Our ref: DOC21/438517
Senders ref: SSD 11437498

Subject: Broken Hill Battery energy Storage System – Environmental Impact Assessment

ATTACHMENT A – BCD Assessment Summary for Broken Hill BESS Environmental Impact Statement (SSD 11437498)
ATTACHMENT B – Detailed comments for Broken Hill BESS Environmental Impact Statement (SSD 11437498)

FIGURE 3-1:
EXISTING DRAINAGE AND CATCHMENTS

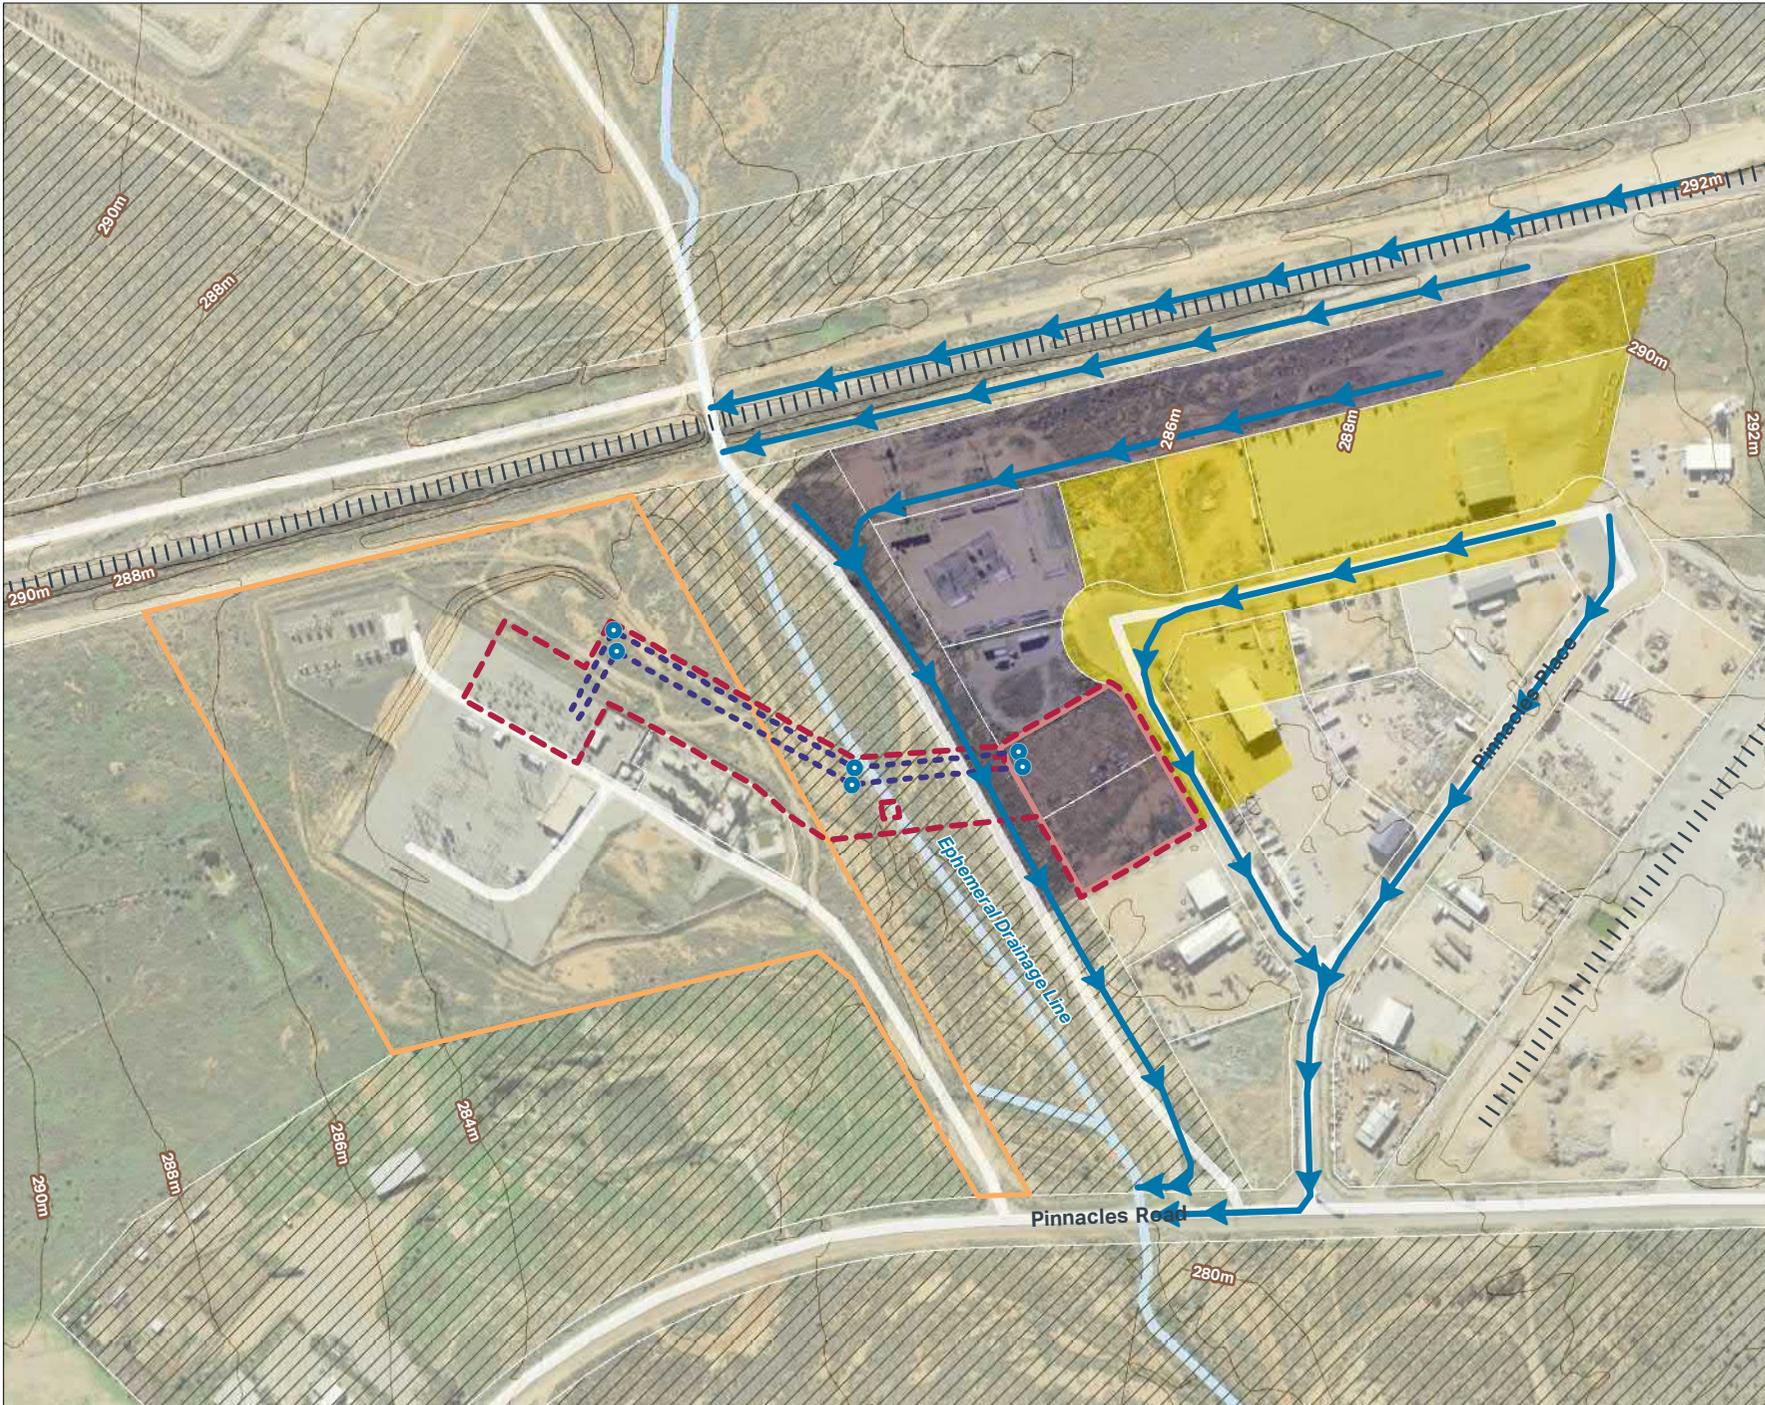
A simple hydrological assessment has been completed that examines the overland flow-related flooding that would occur during high intensity rainfall events originating within the industrial subdivision. However, no assessment seems to have been undertaken of the flows residing in the adjacent ephemeral flow path (that runs adjacent to the site). It is possible that any overland flow event could coincide with a flow emanating in this ephemeral flow path due to the relatively small upstream catchment, which may impact on the site. The flood liability of the proposed development site remains unknown until the flows from these catchments are hydraulically modelled to determine the extent, depths and velocities of the design flood events.

Note that this additional modelling does not have to encompass a complex fully 2-D hydraulic model. It could be a simple 1-D approach that includes the major drainage lines, most crucially the ephemeral drainage line, that allows for the mapping of the major design flood events. It will also allow for the flood liability of the site to be determined and the impacts resulting from the development (internal and external to the site) to be determined.

- 1.1 *Complete quantitative flood modelling and assessments of the overland flow and ephemeral drainage lines to determine the flood liability of the site from all contributing catchments for appropriate design storm events*
